CITY OF ALBUQUERQUE

November 8, 2021

**Re: Albuquerque ER & Hospital
4315 Wyoming Blvd. NE
Traffic Circulation Layout
Engineer's Stamp 10-12-21 (G19-D004D)**

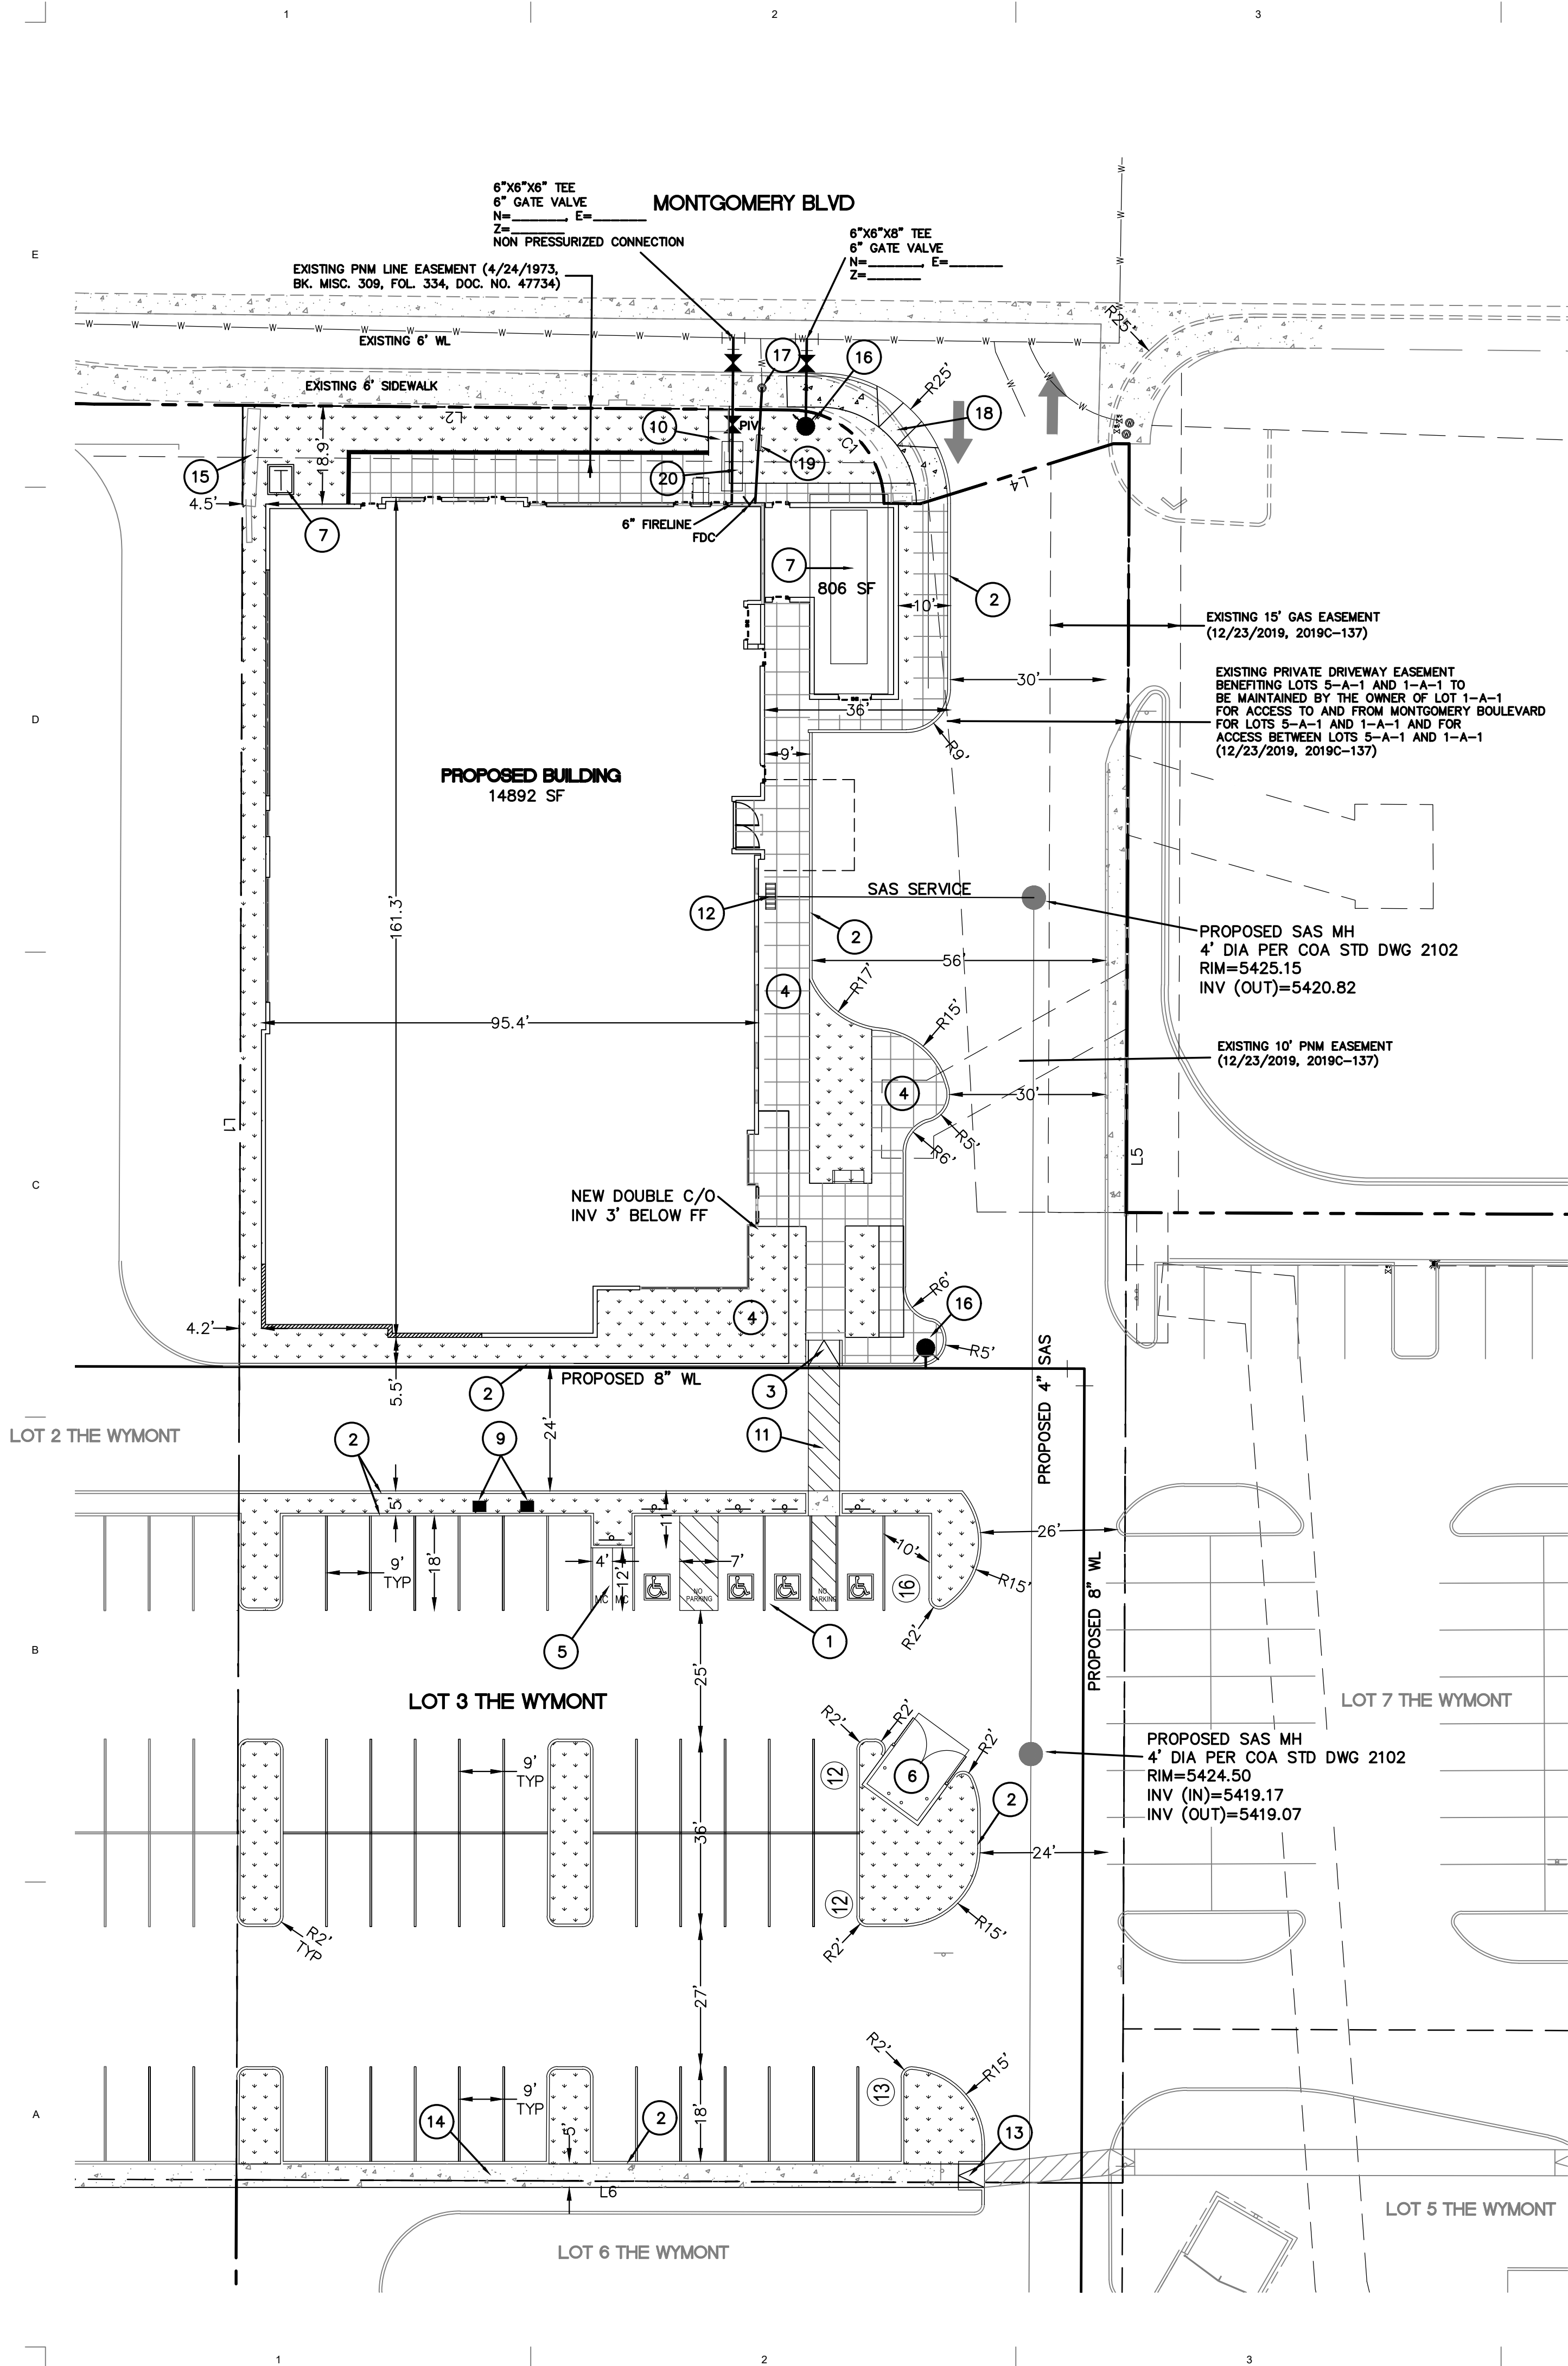
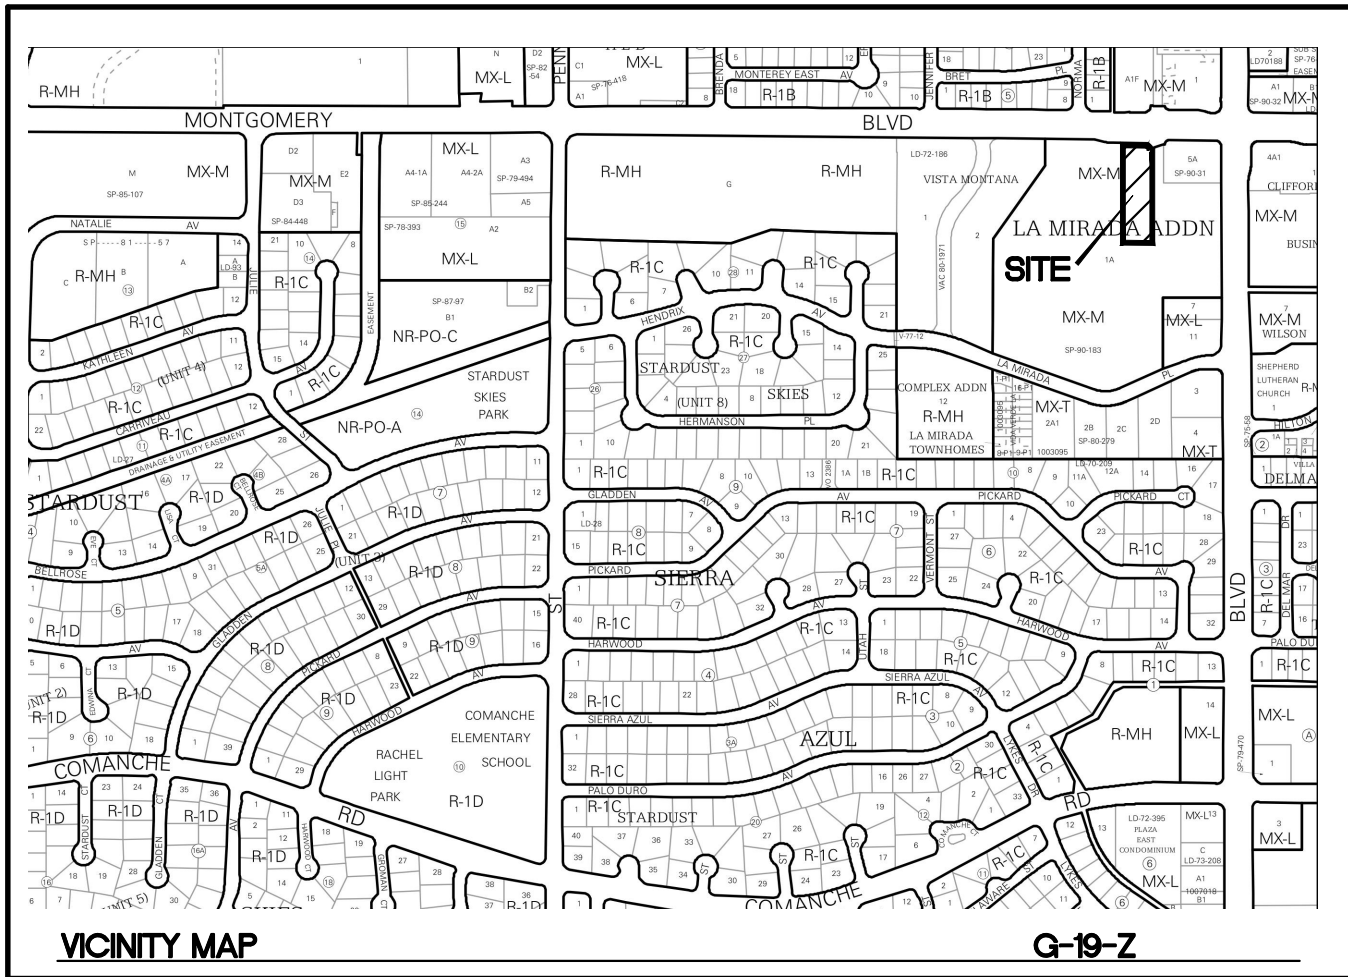
1. List the number of parking spaces required by the IDO as well as the proposed number of parking spaces including bicycle and motorcycle parking. Please coordinate with Zoning because you proposed less parking spaces than the required.
2. Keyed Note 1, 3, 12, 13, & 18: Details' sheet is missing. Provide details for each infrastructure, reference COA standard DWG.
3. Key note 2: Please clarify is it 6ft, or 6in?
4. Key note 7: All the proposed infrastructures should be located inside the property line.
5. Key note 9: Proposed charging station might be in conflict with overhang cars. Suggestion, you may provide curb bumpers in this conflict area.
6. Key note 11: provide cross walk striping details.
7. Identify the right of way width, medians, curb cuts, and street widths on Montgomery Blvd..
8. The minimum parking stall dimensions are:

9. The ADA accessible spaces must include an access aisle. Van accessible aisles should be 8ft wide; all others should be 5ft wide.
10. The ADA accessible parking sign must have the required language per 66-7-352.4C NMSA 1978 **"Violators Are Subject to a Fine and/or Towing."** Please call out detail and location of signs.

16. Per the IDO, a 6 ft. wide ADA accessible pedestrian pathway is required from the public sidewalk to the building entrances. Please clearly show this pathway and provide details.

17. Per DPM, a 6 ft. wide ADA accessible pedestrian pathway is required from the ADA parking stall access aisles to the building entrances. Please clearly show this pathway and provide details.

18. Parking areas shall have barriers to prevent vehicles from extending over public sidewalk, public right-of-way, or abutting lots.
19. Refuse vehicle maneuvering shall be contained on-site. The refuse vehicle shall not back into the public right of way; provide a copy of refuse approval.

20. Provide Fire Marshal Approval.
21. It is not apparent what type of pavement surface is being proposed. A hard driving surface will be required as part of this proposed project for parking area and drive aisles.

22. Please provide a sight distance exhibit
23. Show the clear sight triangle and add the following note to the plan: "Landscaping and signage will not interfere with clear sight requirements. Therefore, signs, walls, trees, and shrubbery between 3 and 8 feet tall (as measured from the gutter pan) will not be acceptable in the clear sight triangle.

24. Add note for existing Pedestal Sign to be located inside private property which includes Air Space.
25. Please specify the City Standard Drawing Number when applicable.

26. Shared Site access: driveways that straddle property lines, or are entirely on one property but are to be used by another property, shall have an access easement.
